**REQUEST**

Current Zoning: N1-A (neighborhood 1-A), CG (general business)  
Proposed Zoning: I-1(CD) (light industrial, conditional)

Approximately 3.55 acres bound by the east of side of Lakebrook Road, north side of Centergrove Lane, west side of Sam Wilson Road, and south side of Interstate 85.

The petition proposes to allow the development of convenience store with gas and diesel fuel pumps along with accessory and incidental uses associated with the principal use. The site is currently undeveloped.

FILE LOCATION: \\s:\Drawings\Projects\QuikTrip\1001 (Charlotte, NC)\81-1001 Civil.dwg TAB NAME: Rezoning Plan USER: EdEnser SAVED: 1/19/2024 11:43 AM PLOTTED: 1/19/2024 3:13 PM

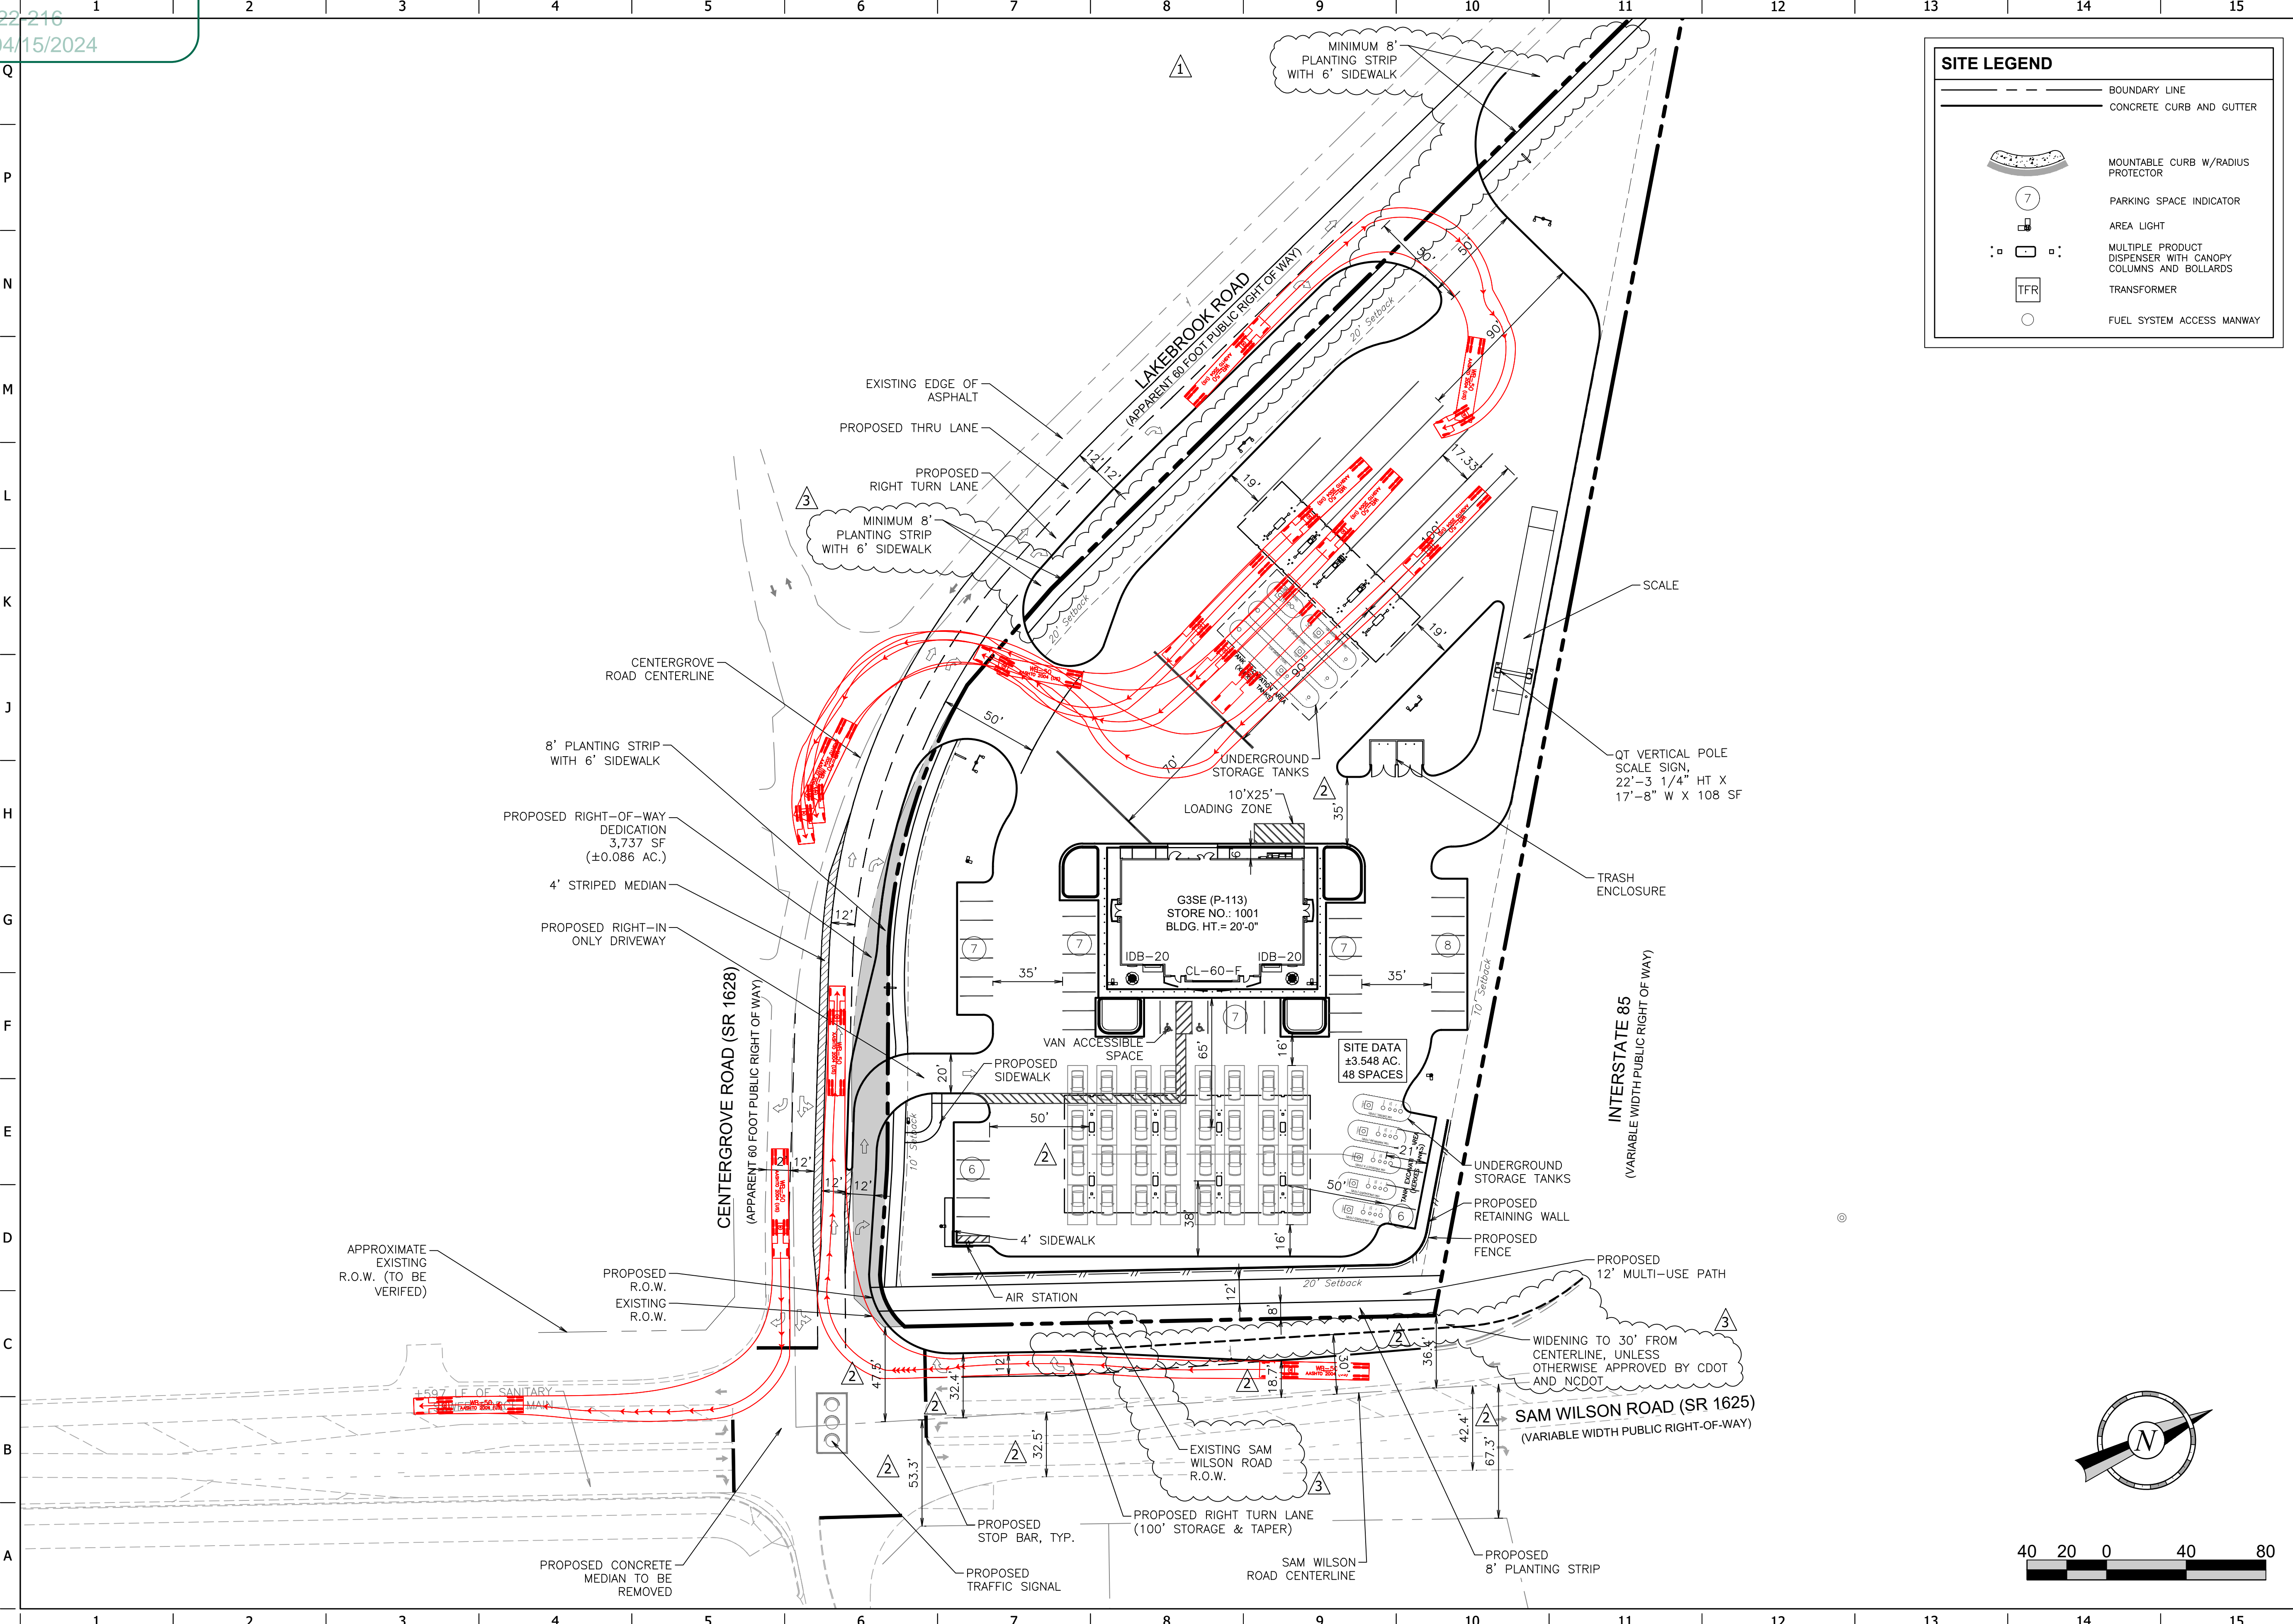
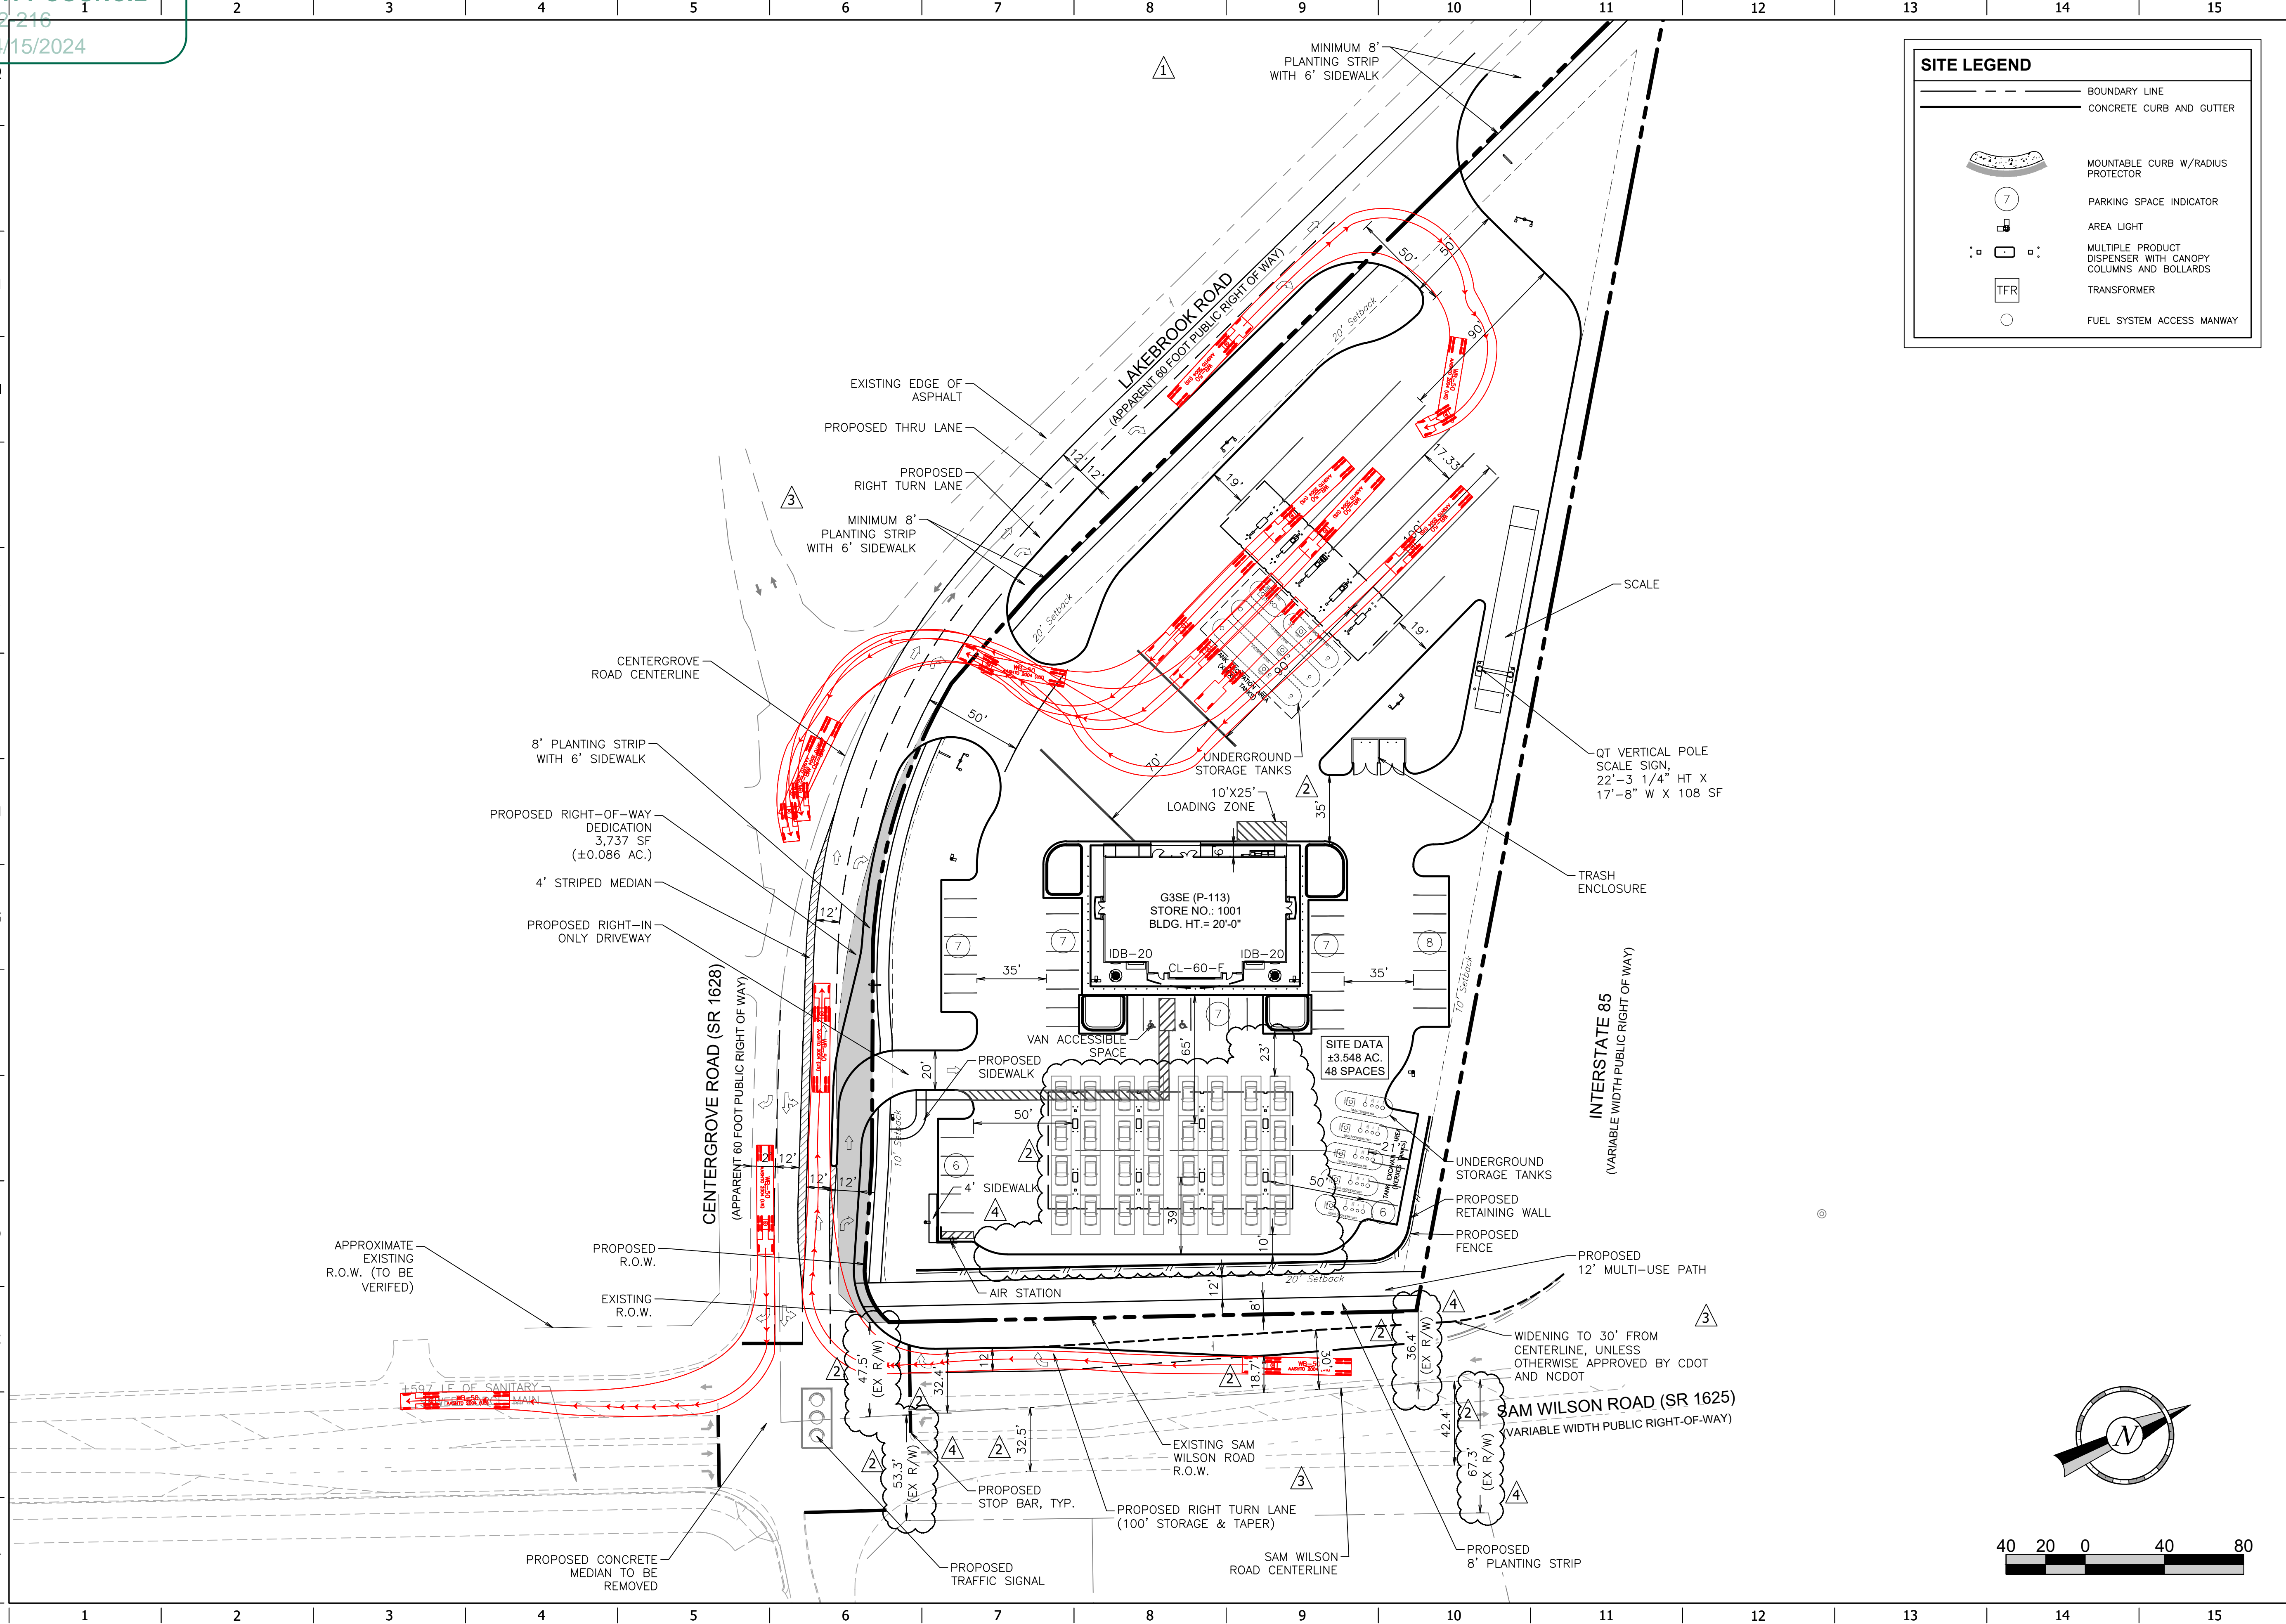
- The site is located on the north side of Centergrove Lane, a State-maintained local street, west of Sam Wilson Road, a State-maintained minor thoroughfare. A Traffic Impact Study (TIS) is required for this site and was approved by CDOT on 11-27-2023. Site plan and/or conditional note revisions are needed including labeling and dimensioning right-of-way/curb and gutter elements from centerline.

1. ~~Location of curb and gutter to be moved to 30 feet from roadway centerline to accommodate the Charlotte Streets Map with a roadway typical section of a 4+ avenue with a 12-foot multi-use path. Label and dimension curb and gutter 30 feet from roadway centerline on Sam Wilson.~~ **ADDRESSED**

2. ~~Revise site plan and conditional note(s) to commit to dedicate 35 feet of right of way from the road centerline on Sam Wilson Road. The site plan shall label and dimension the right of way from the road centerline. Label and dimension right of way from roadway centerline on Sam Wilson.~~ **ADDRESSED**

3. ~~Revise site plan to clearly show and label where existing right of way is and proposed right of way.~~ **ADDRESSED**
4. ~~Revise site plan and conditional note(s) to construct 8-foot planting strips and 6-foot sidewalks on Centergrove Lane and Lakebrook Road and a 12-foot multi-use path on Sam Wilson Road. The site plan shall label and dimension both items from the back of curb and gutter or edge of pavement. Add conditional note The entire facility must be outside of the right of way and within a public access easement. Add conditional note committing to construction and maintenance of the 6-foot sidewalk on Centergrove Lane and the 12-foot multi-use path on Sam Wilson Road. Add conditional committing to maintenance of 6-foot sidewalk on Centergrove Lane.~~ **ADDRESSED**
